DRAWN BY: O.E. WATTS	APPROVED BY:	REVISIONS	OLIVER E. WATTS CONSULTING ENGINEER COLORADO SPRINGS	PROJECT 16140 OLD DENVER ROAD PART NW1/4 SEC. 26, T.11S., R.67W, 6TH P.M. EL PASO COUNTY	SHT. NAME CONSTRUCTION DOCUMENT COVER SHEET	SHT. NO. 1 OF 3	
	DATE: 10-23-19	PROJ. NO.						
	DWG. NO.: 17-4958-06	DWG.

CONSTRUCTION DOCUMENT
GRADING AND EROSION CONTROL PLAN

DRAWN BY: O.E. WATTS DATE: 10-23-19 DWG. NO.: 17-4958-05	APPROVED BY: PROJ. NO. DWG.	REVISIONS 5-15-20 REVISED PER CITY REVIEW COMMENTS DEW	OLIVER E. WATTS CONSULTING ENGINEER COLORADO SPRINGS	PROJECT 16140 OLD DENVER ROAD PART NW1/4 SEC. 26, T.11S., R.67W. 6TH P.M. EL PASO COUNTY	SHT. NAME CONSTRUCTION DOCUMENT EROSION CONTROL DETAILS	SHT. NO. 3 OF 3
--	-----------------------------------	---	--	---	---	--------------------------

OUTLET WORKS PROFILE
1/2"=1'-0"

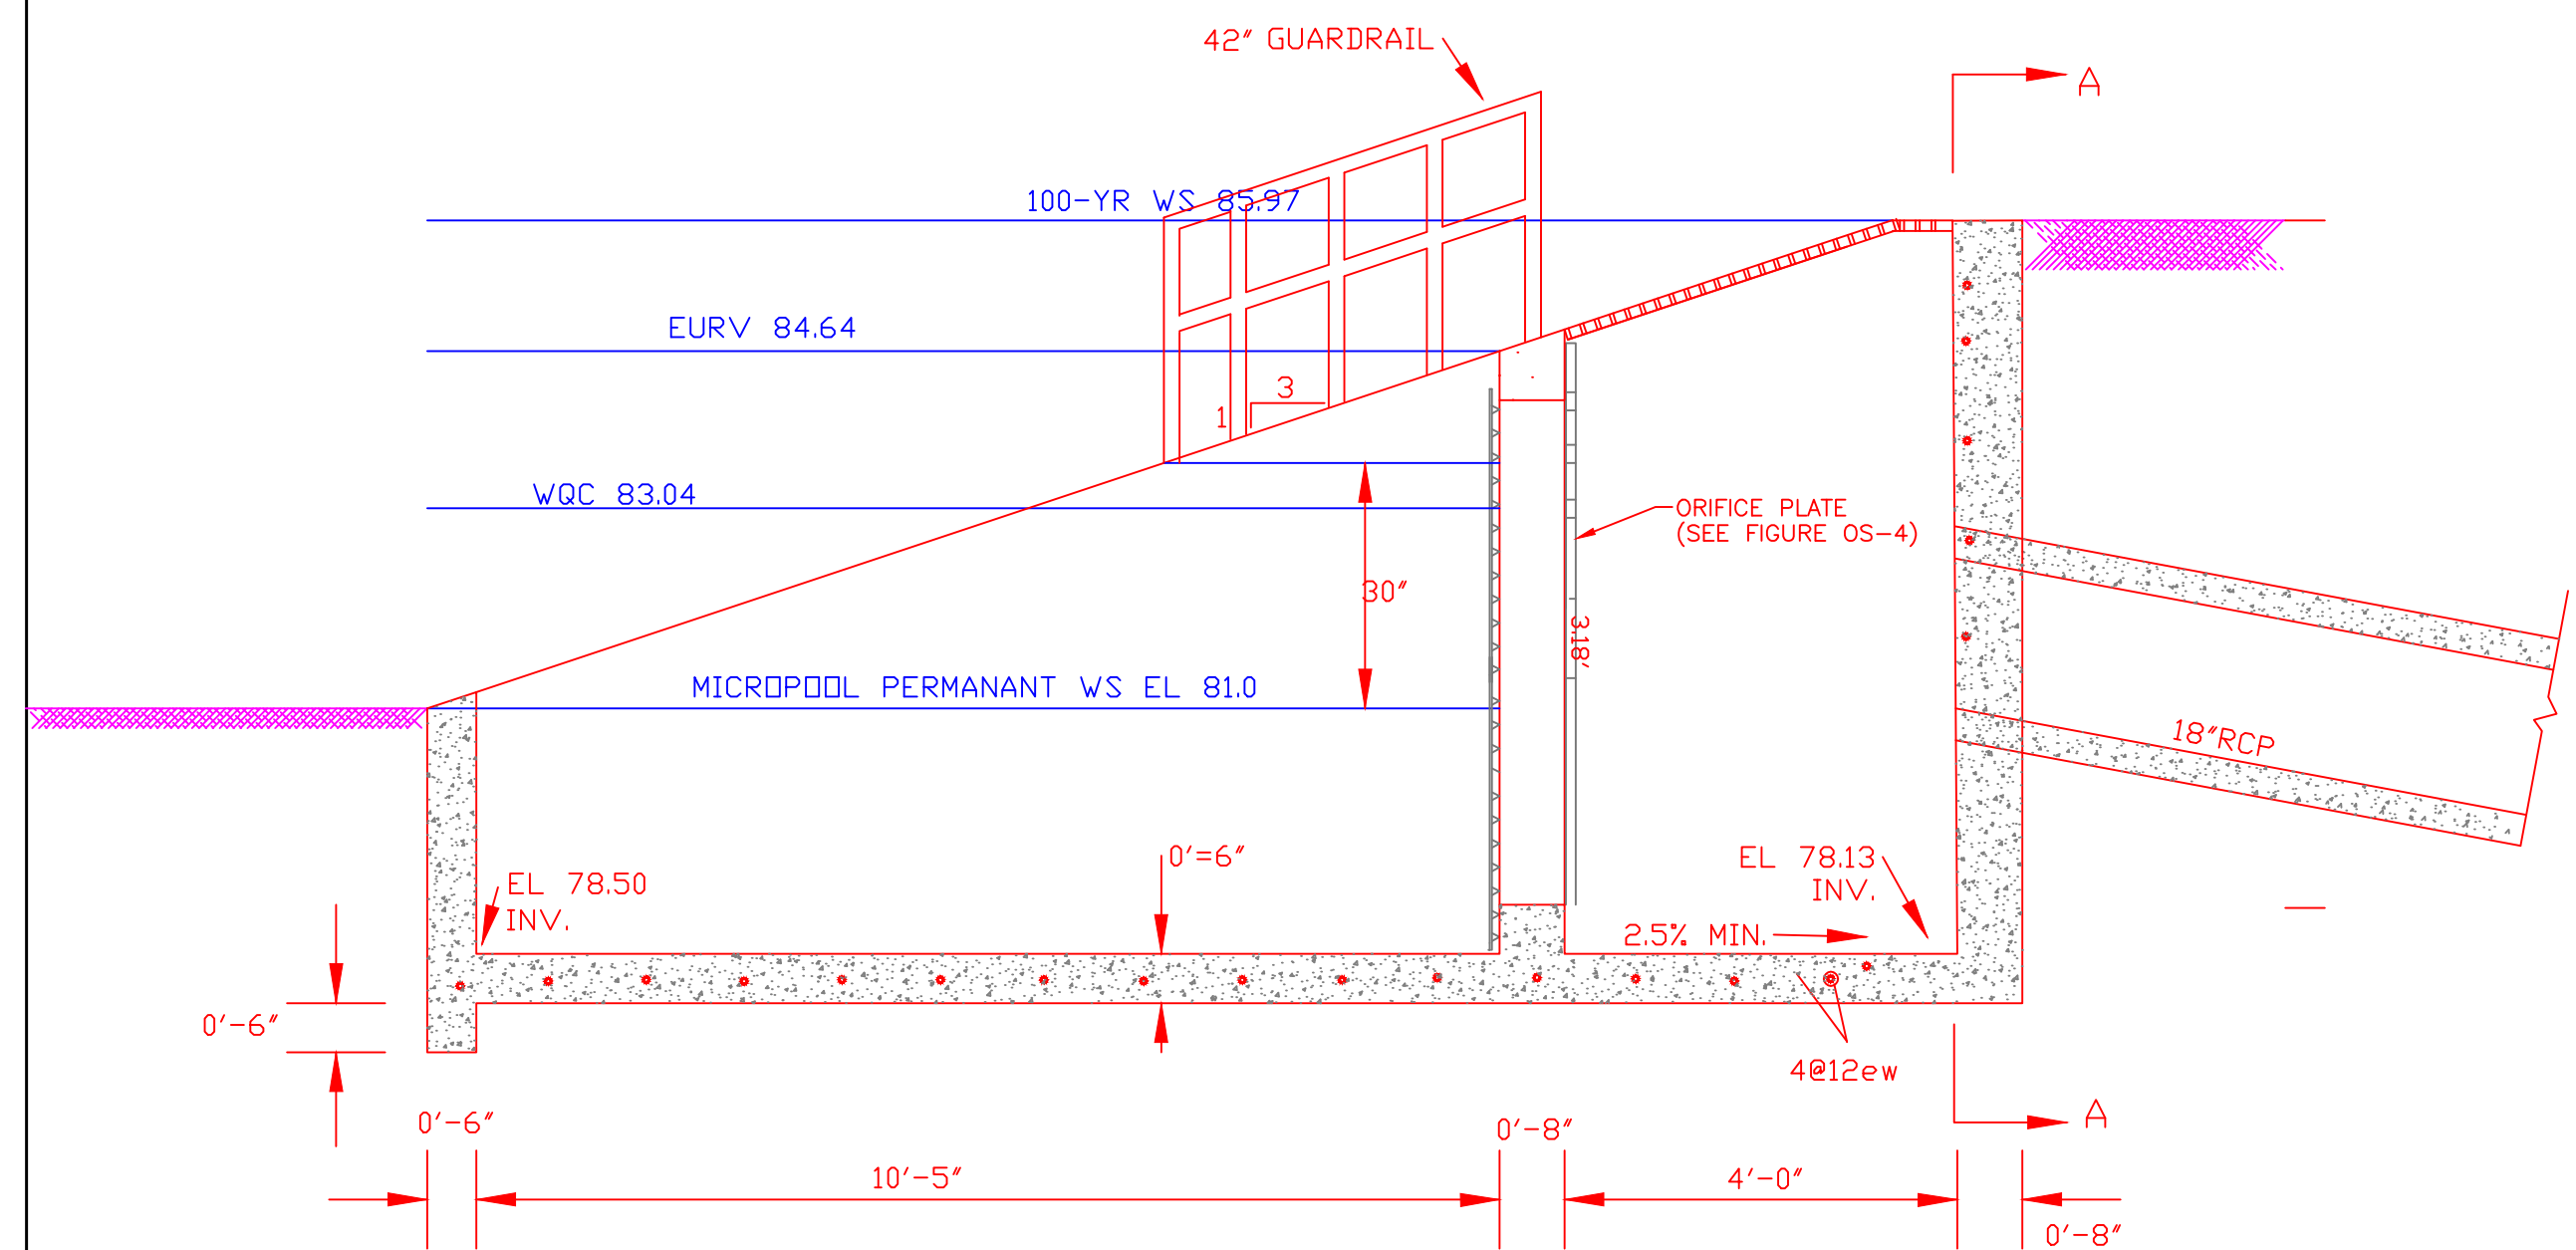
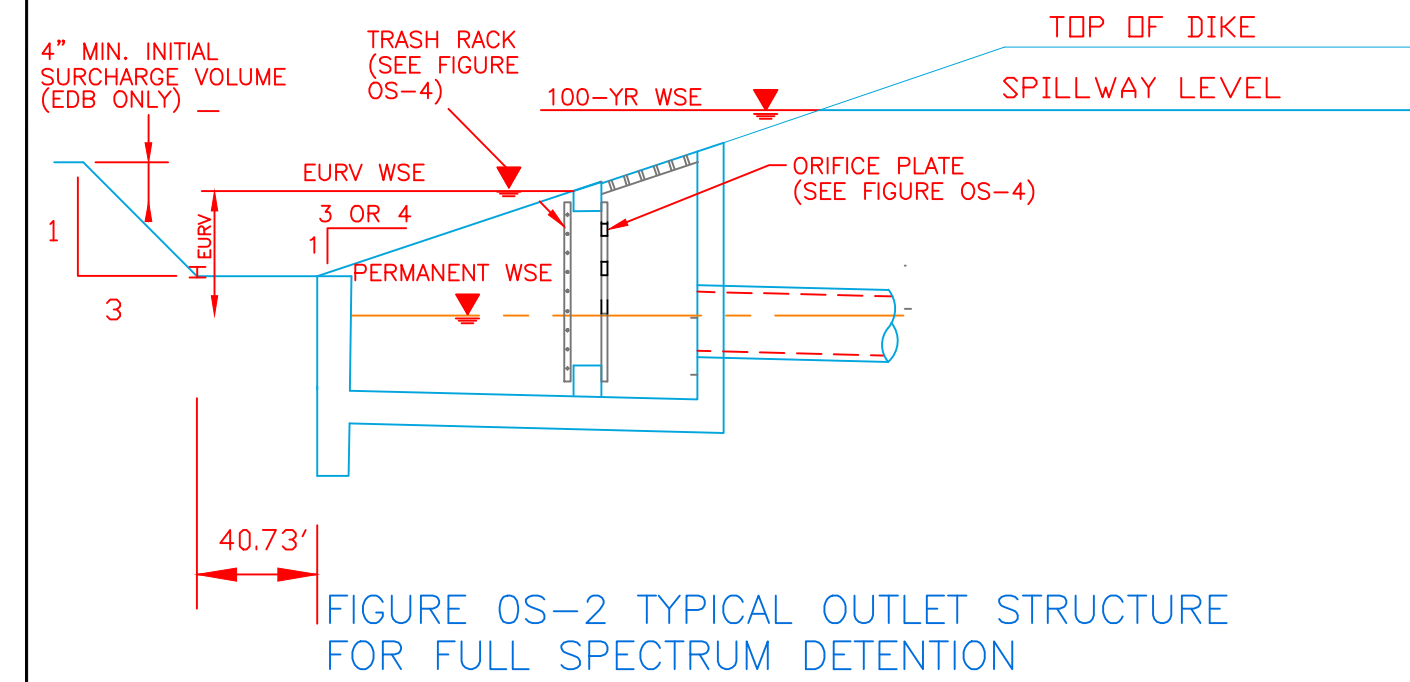
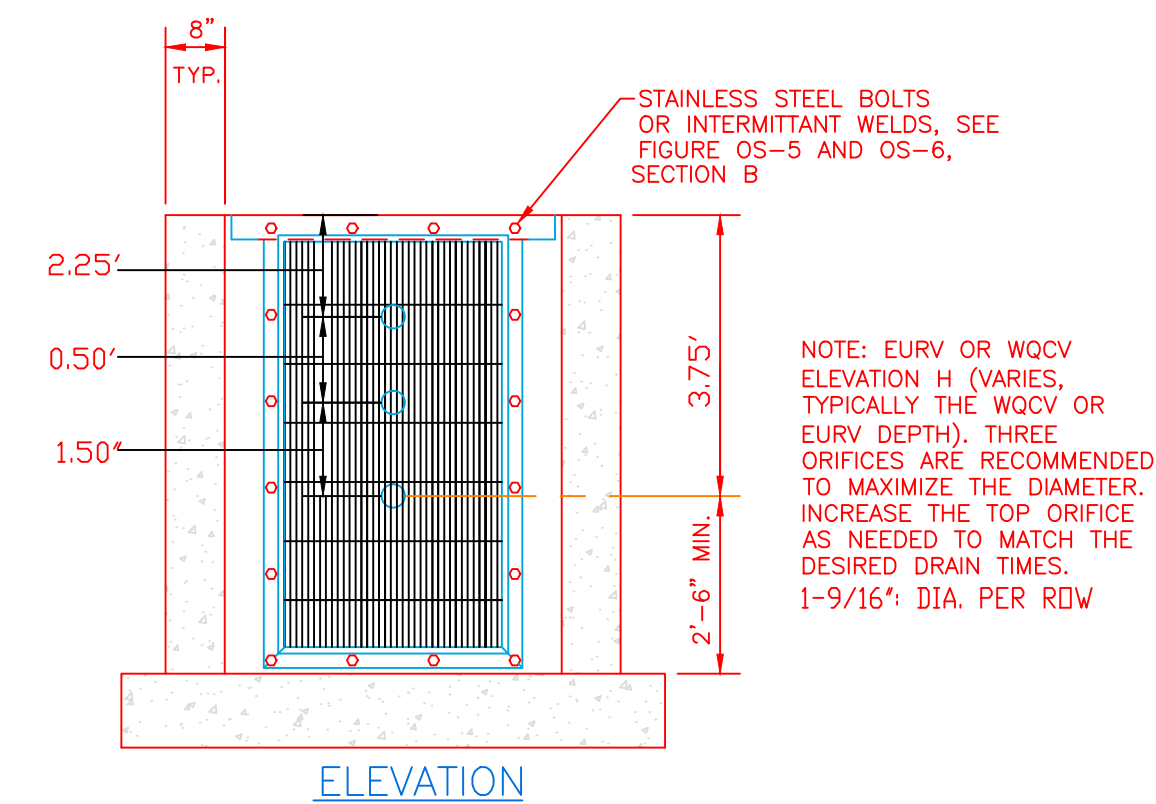
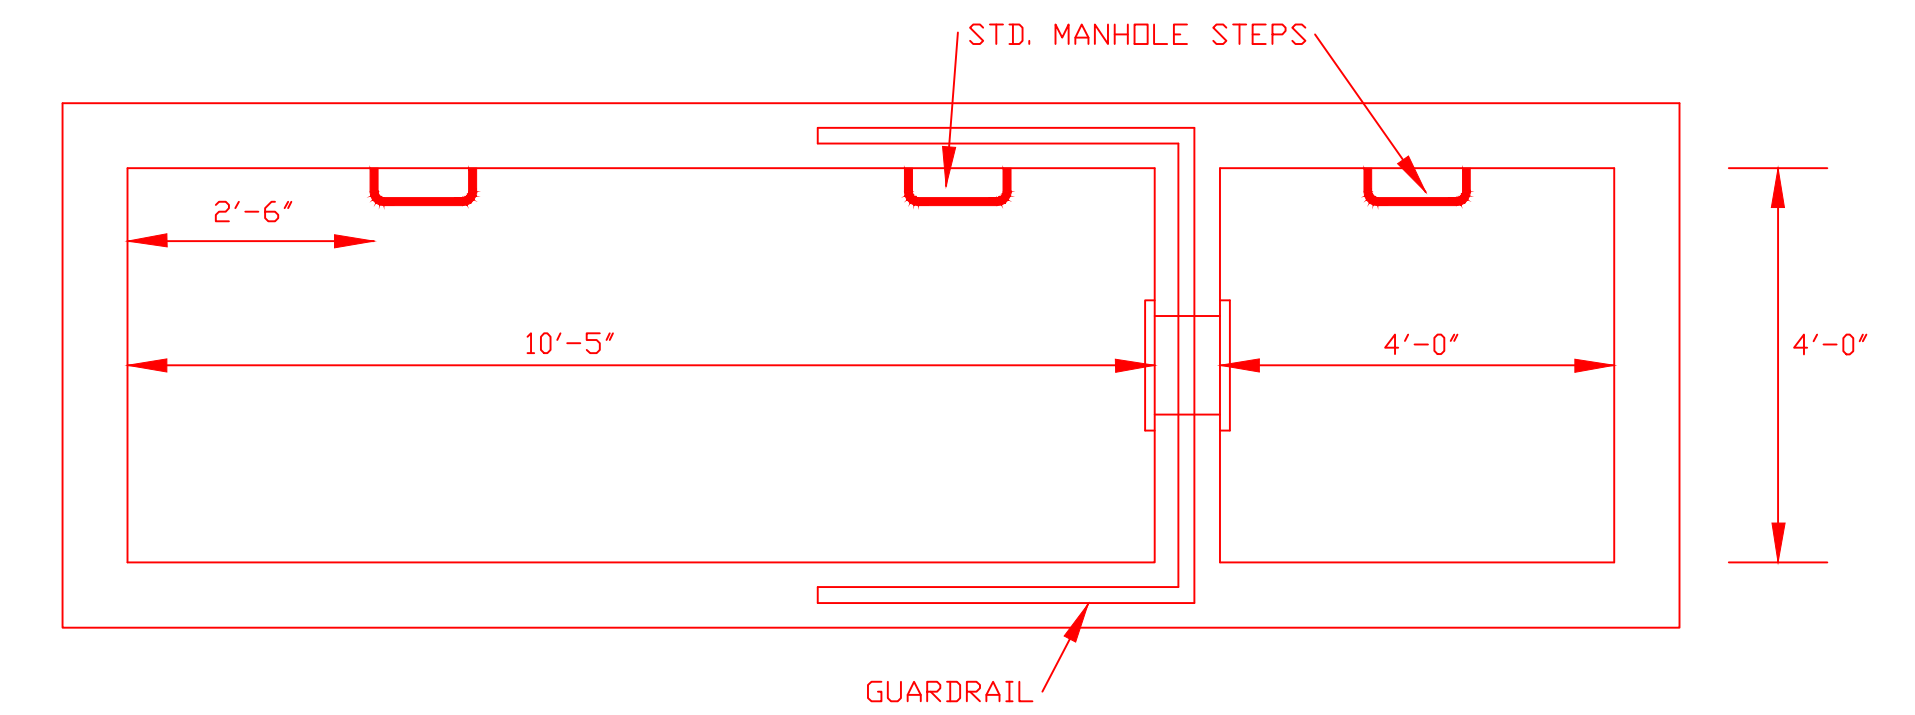
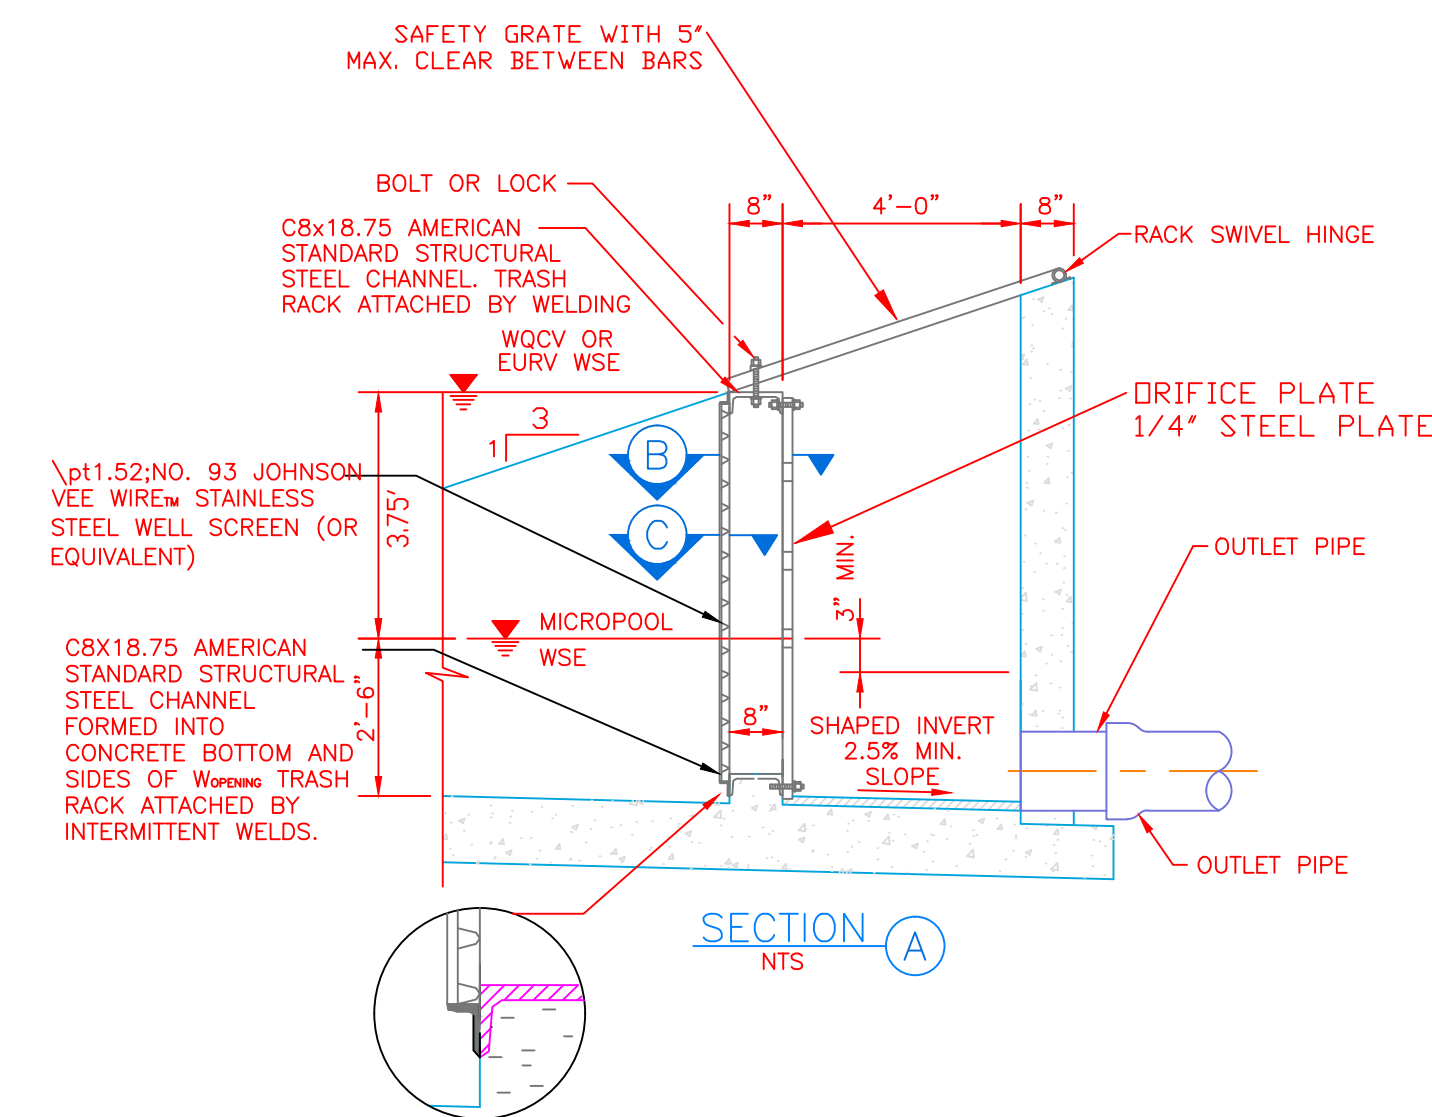
Replace trash rack. Galvanized square mesh screen is not trash rack. Use either a No. 93 Johnson Vee Wire Stainless Steel Well Screen or Amico Klemp SR Series Aluminum Bar Grate. See the standard outlet structures details in Appendix F.

Callout to provide continuous neoprene gasket between orifice plate and structure.

The orifice plate design will likely be revised. Outlet structure will be reviewed on the resubmittal.
